**PLANNING ACT 2008  
THE INFRASTRUCTURE PLANNING (EXAMINATION PROCEDURE) RULES 2010**

**Application by London Resort Company Holdings for an Order granting Development  
Consent for the London Resort (ref: BC080001)**

**RELEVANT REPRESENTATION  
by the Port of London Authority**

Scale: **1 : 2500 @ A1** Sheet: **4 of 9** Revision: **0**

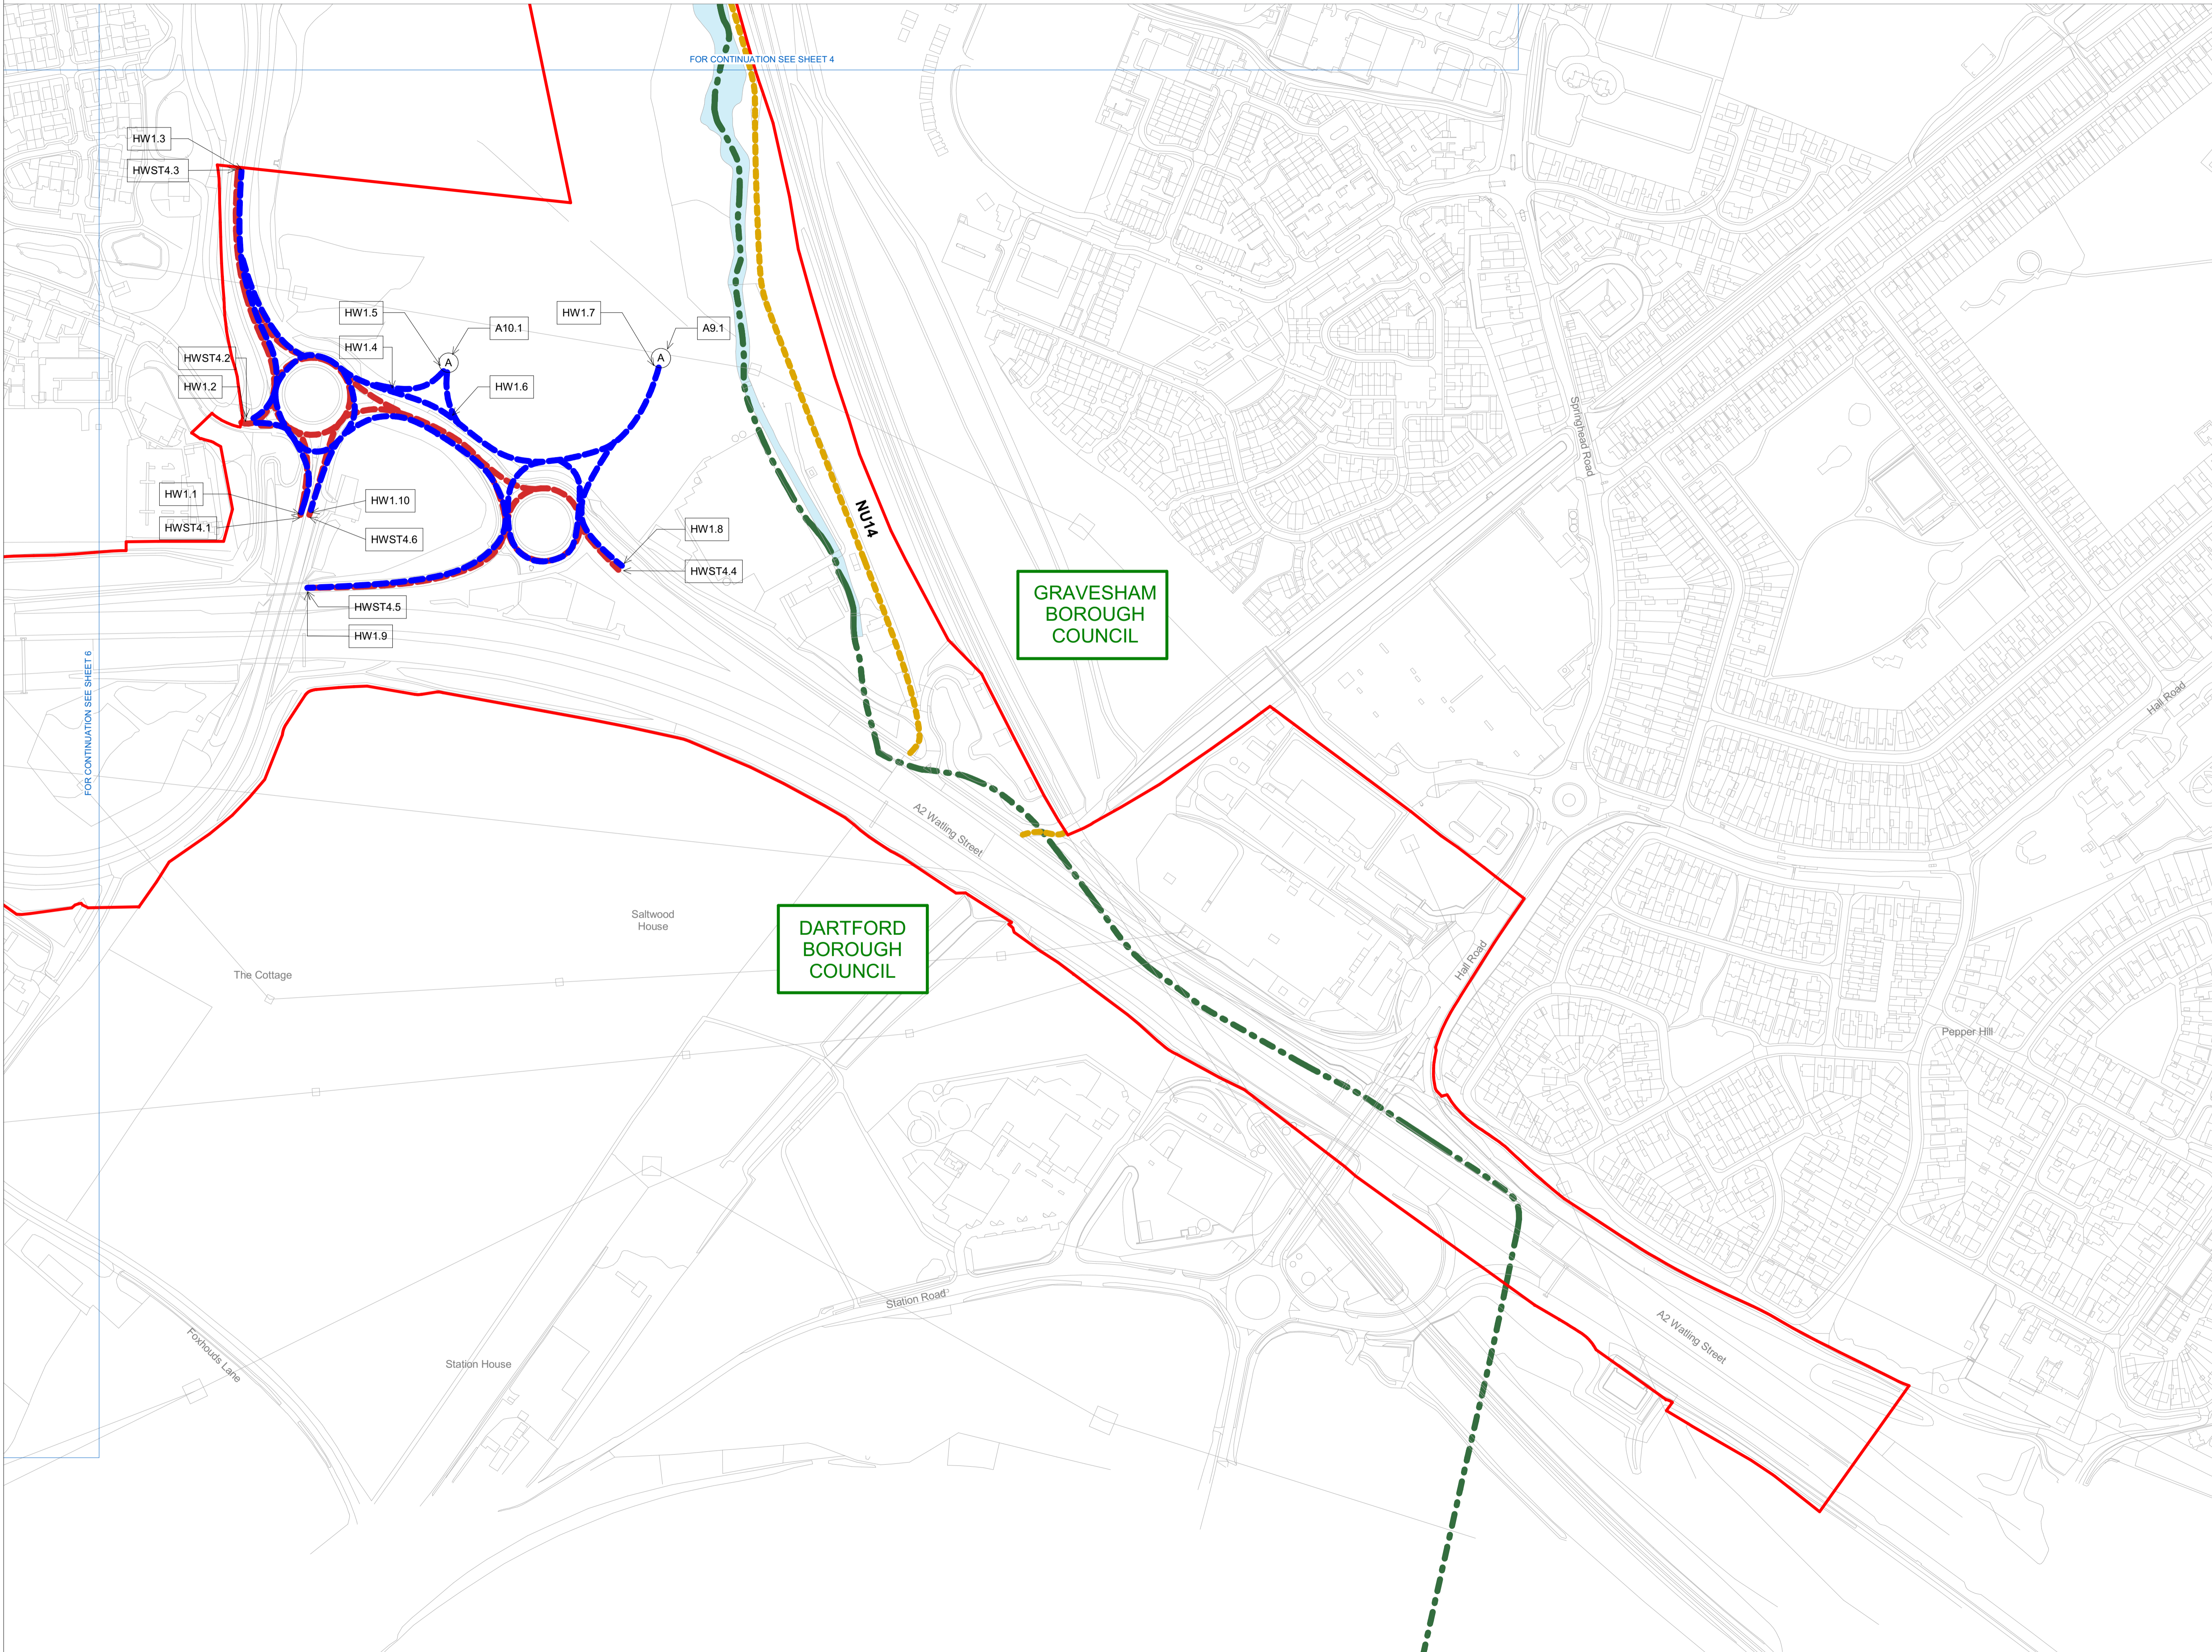
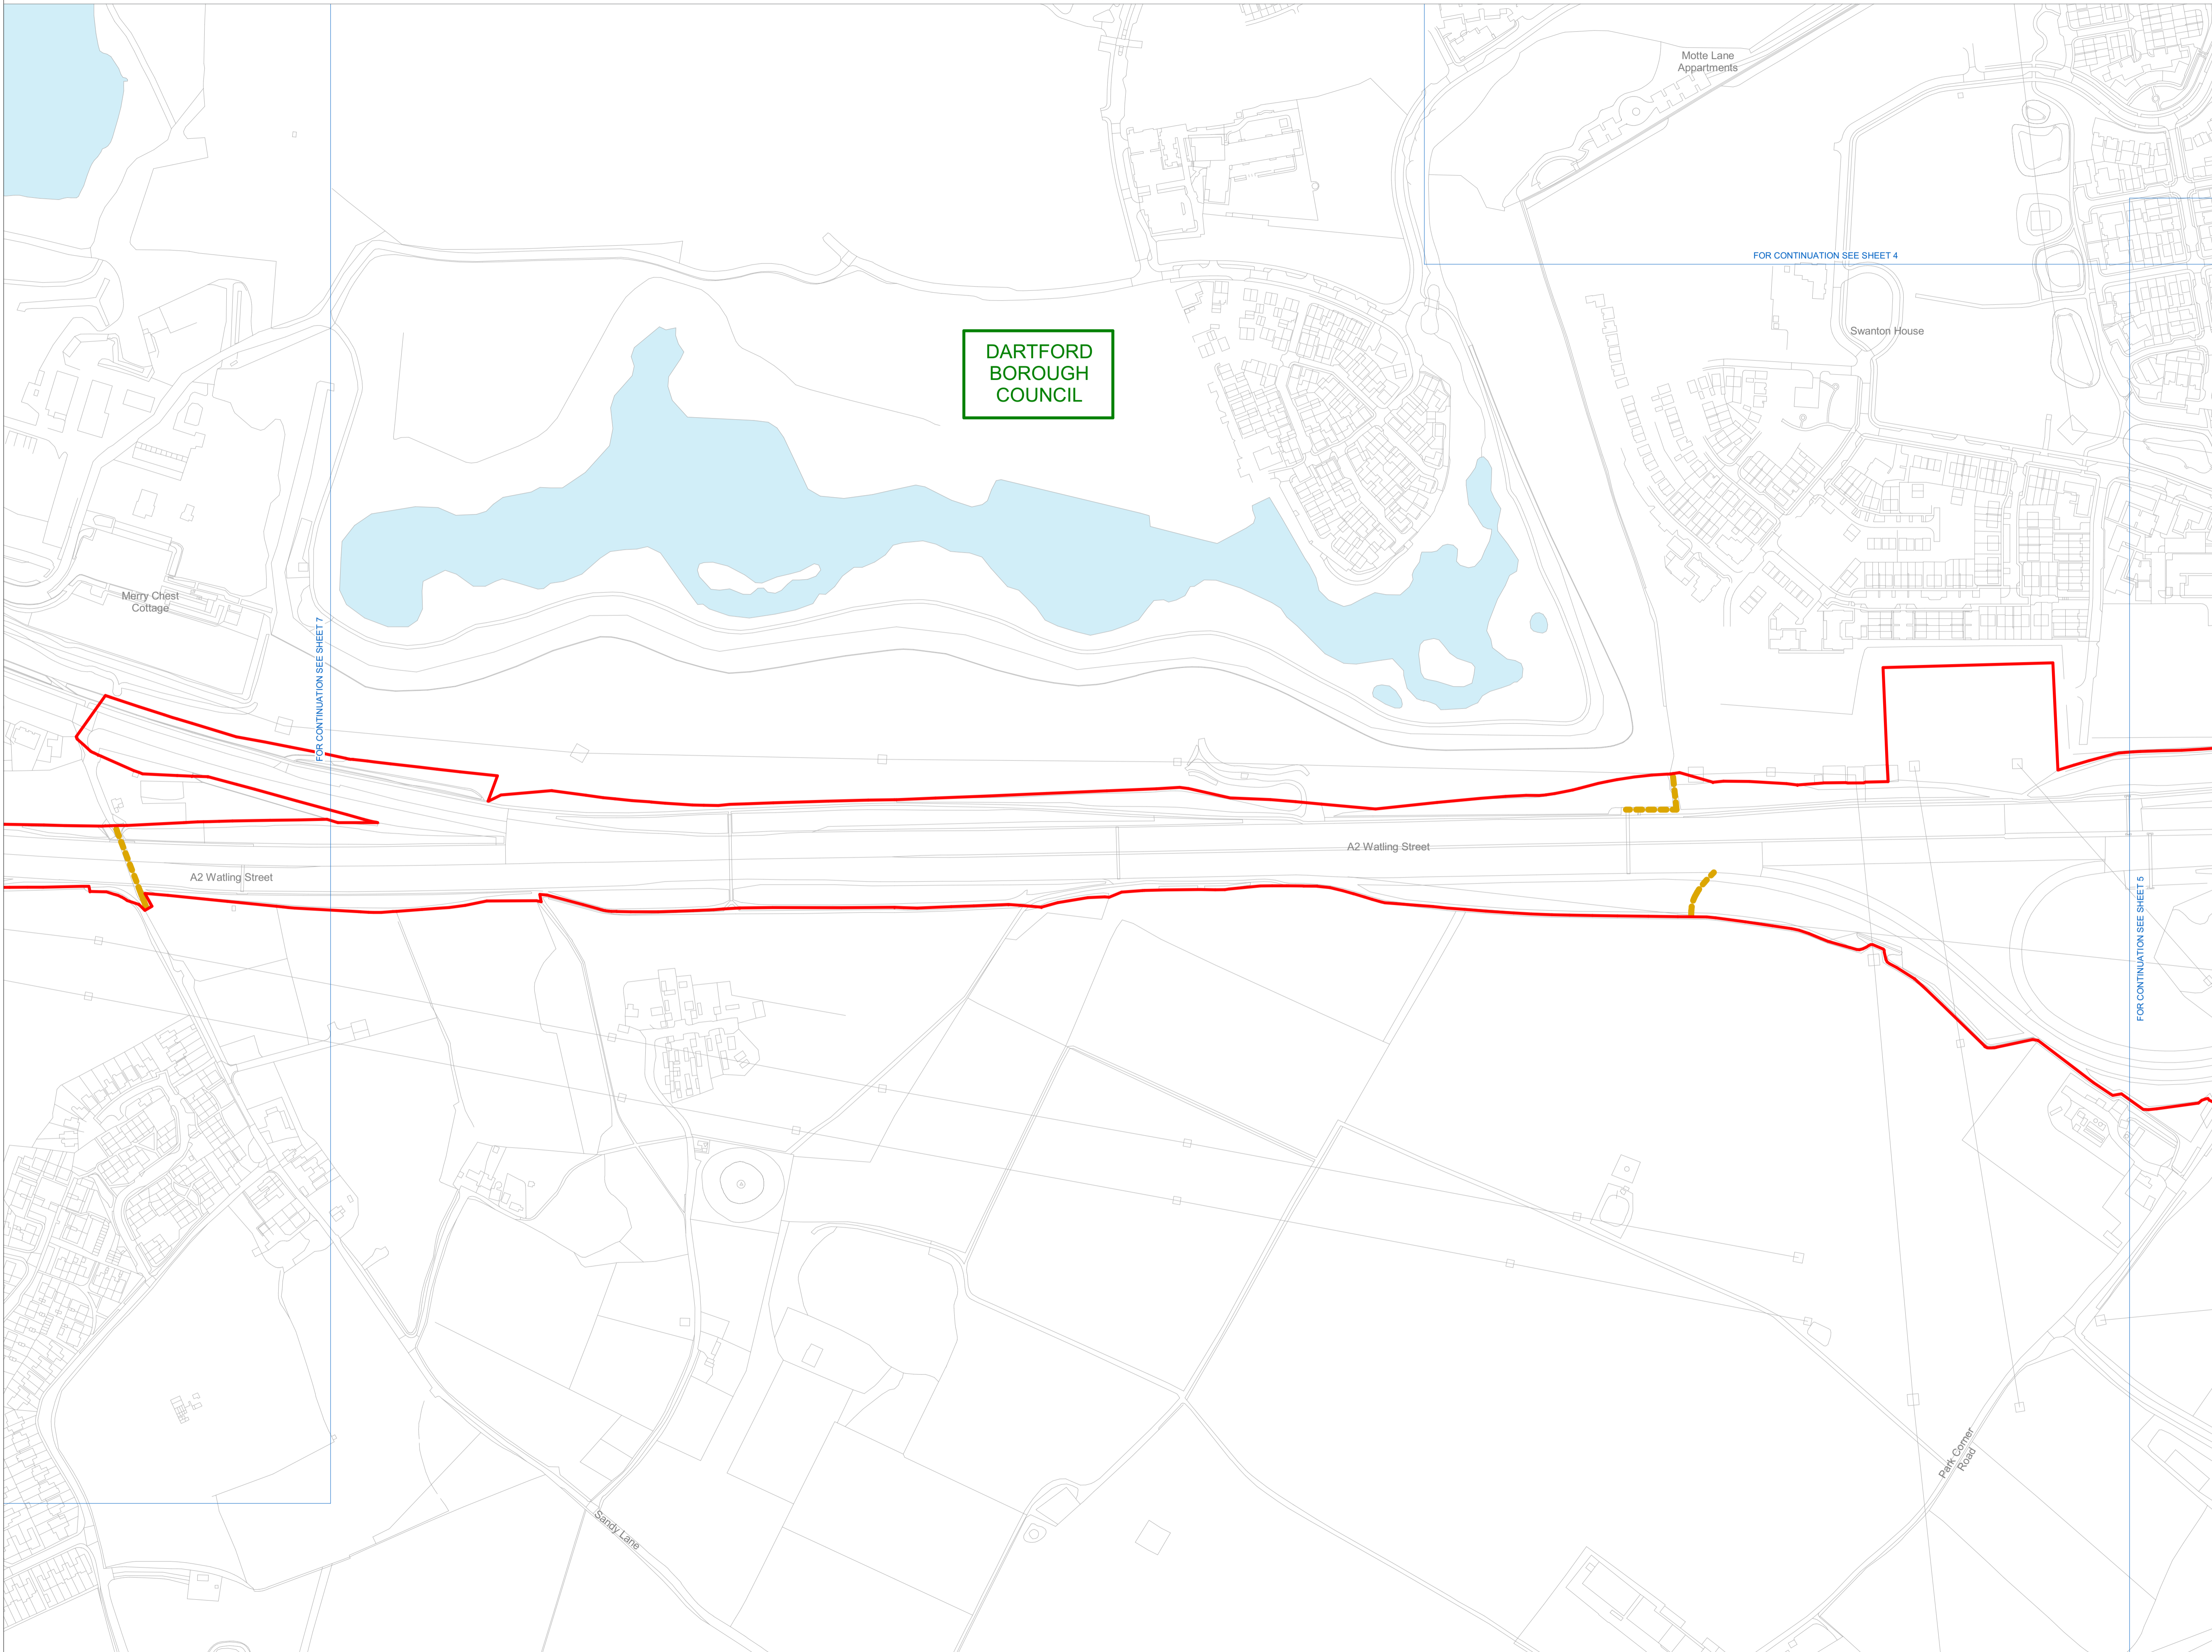
4. **Drafting of the Order and plans**
  - 4.1 The drafting of the Order and the plans submitted with the application fail to clearly indicate the applicant’s intentions regarding the river and its foreshore. There is insufficient detail provided in respect of works and operations within the river and foreshore to provide the PLA with certainty as to the nature and extent of those works and their construction, and also the scope and extent of any temporary works in, and possession of, the river.

of the disapplied provisions. The PLA takes issue with other provisions of the Order, including but not limited to: interference with/suspension of public rights of navigation (arts. 31(13) and 39); the amendment of existing byelaws (art. 49) and the making of new ones (art. 50); and the extinguishment of existing river works licences (art. 9(4)).
